## **Kirklees Flood Management & Drainage (Lead Local Flood Authority) –**

**Consultation on Application Number: 2018/94067**

**Address: 6, Bar Street, Batley, WF17 5PG**

PROPOSED GROUND FLOOR PLAN.

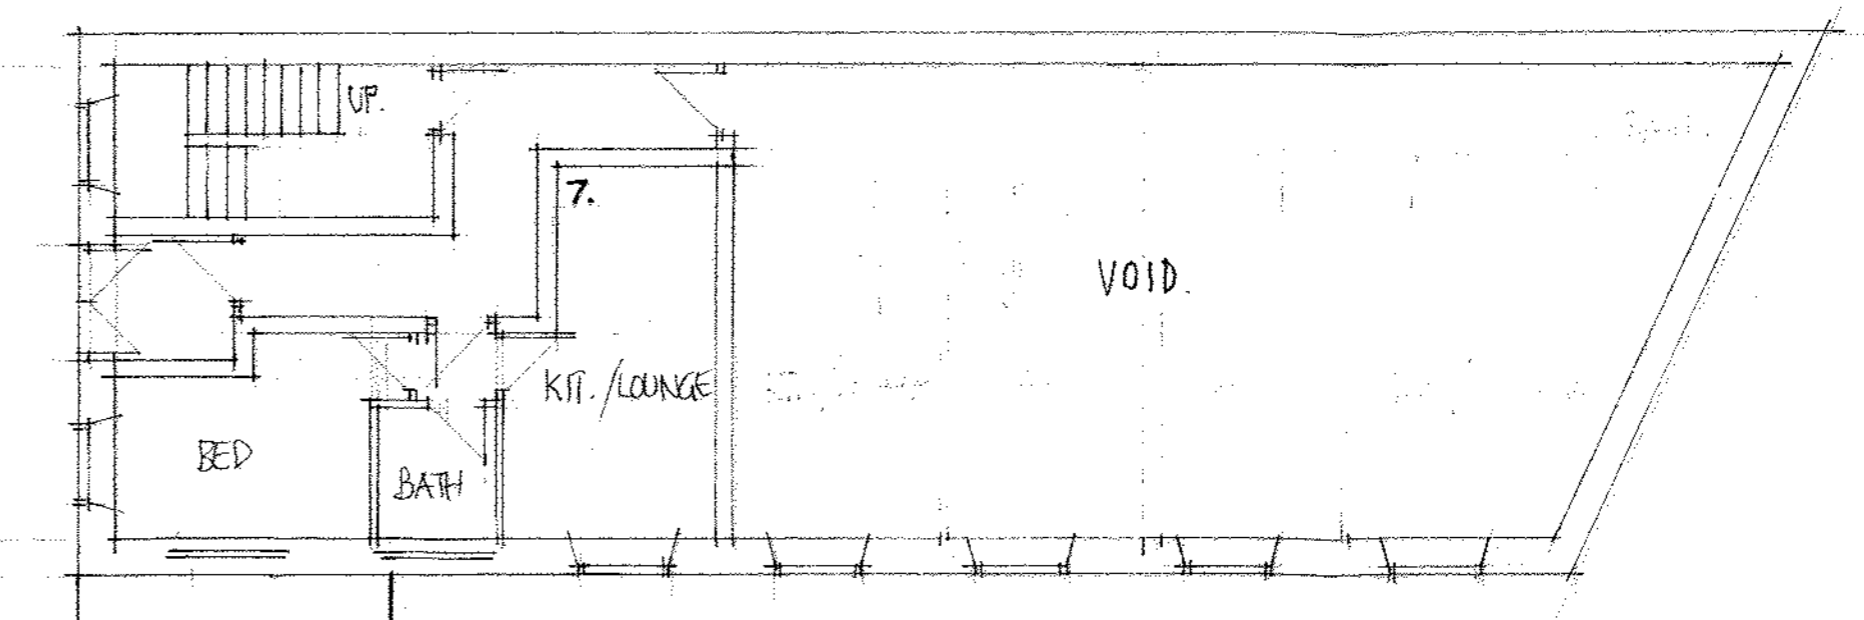
- **Part of the proposed development is in both flood zone 2 and 3. In the proposed layout the ground floor dwelling is in the west of the mill, despite the flood zones only covering the east of the building the zones suggest that water may get into the mill. This means that there is the potential for flood waters to impact the dwelling and exit.**
- **We require more information on the finished floor levels in relation to the main river flooding depths, details of Main River flooding depths can be obtained from the Environment Agency. We expect the FFLs to be 300mm+ above the 1:100 (+ climate change as advised in NPPF) flood depths.**
